Architectural Design Report - Response to Submission

# UNSW Health Translation Hub

This report has been prepared on behalf of UNSW as an addendum to SSD 10822510 for the Health Translation Hub building.

The report has been compiled to respond to the design-related submissions received by the Department of Planning and Environment and Randwick City Council during the public exhibition of the UNSW HTH.

Level 08	
scale	1 : 250@A1
drawn	TH
checked	JC
project no	190551.00
drawing no.	DA1009
issue	D

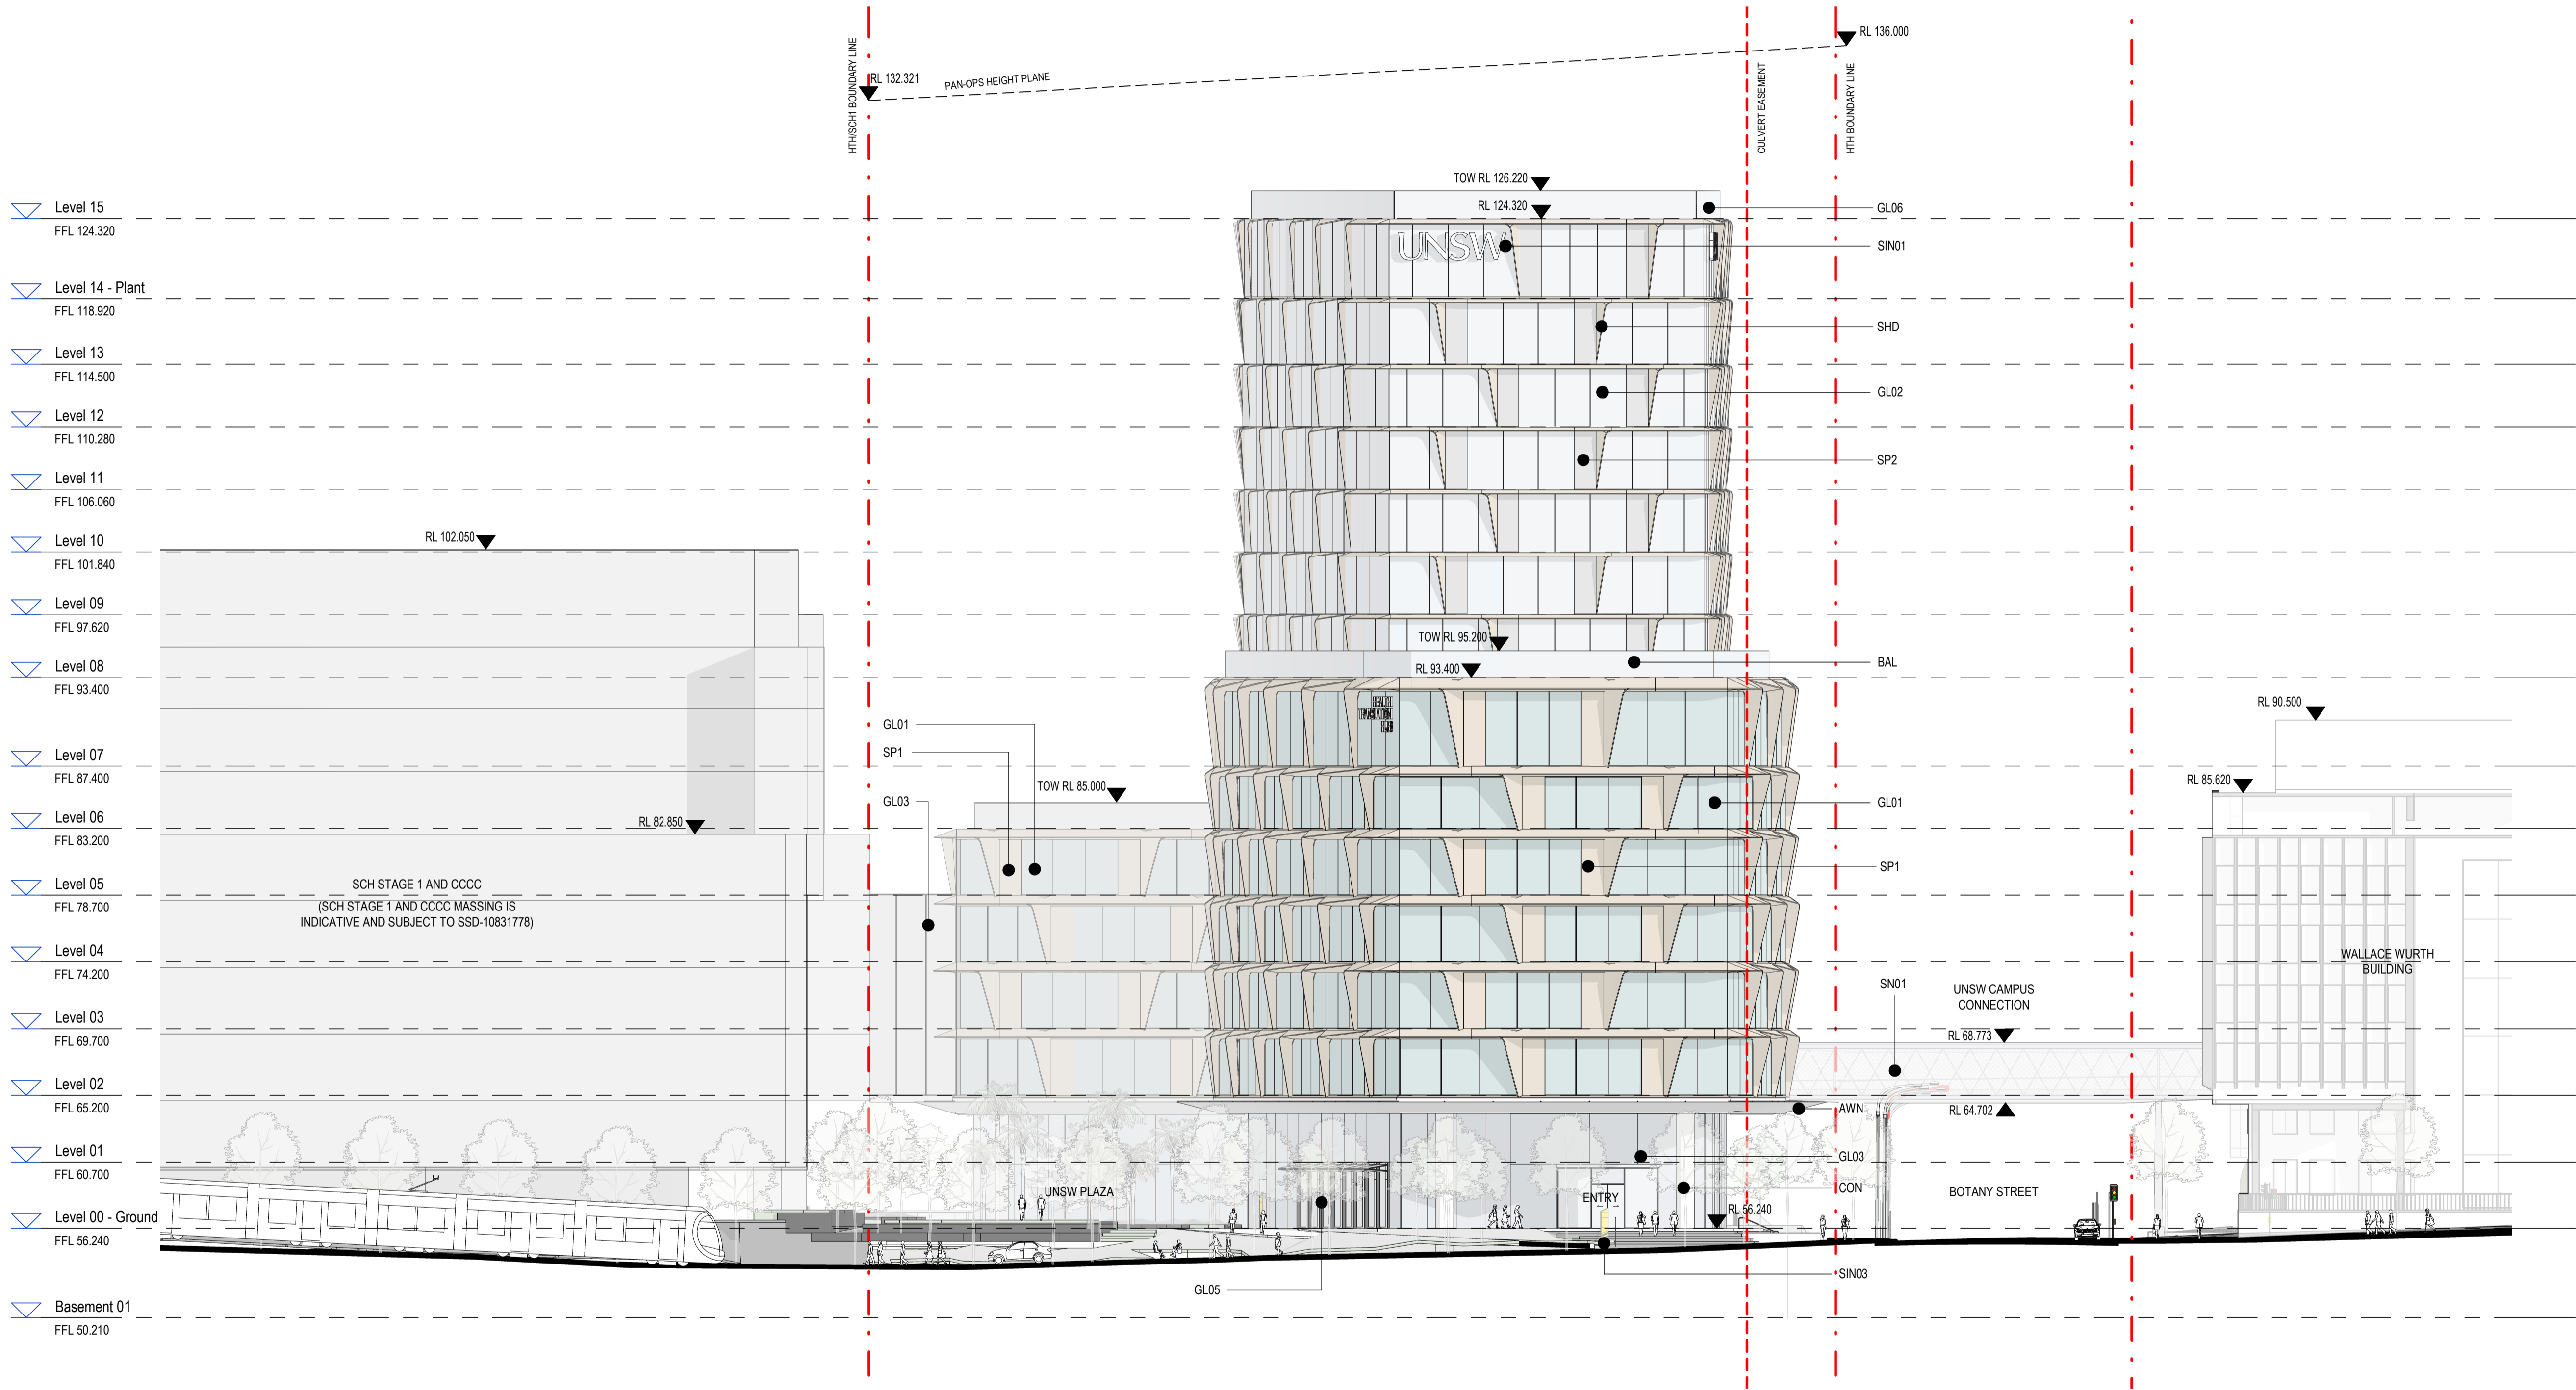
Further consideration should be given to the provision of outdoor roof terraces to provide amenity for occupants as well as opportunities for outdoor learning or breakout spaces. GANSW have advised that “no access to outdoor learning or breakout spaces is considered a poor outcome”.

Further landscape detail is required for the proposed roof level and upper level terraces. The podium roof areas should be utilised to provide outdoor landscaped terrace areas for workers and visitors where possible.

- Include any proposed landscaping of terraces or podium roof levels.”

The design team supports the recommendation to make the roof top terrace spaces accessible and include additional landscaping. The northern roof top that is accessible from level 8 has been selected as the most appropriate location due to its northern aspect, expansive views and advantageous weather/wind protection.

This has been reflected in the revised level 8 plan, that includes a mixture of accessible outdoor amenity to the north and maintenance zones to the east and west.

The design team have indicated a landscape zone on the level 8 rooftop podium, it is designed as a simple space to allow for flexibility for any future tenancy requirements. Noting that there is not sufficient soil volume due to the space constraints to allow for trees within this area.
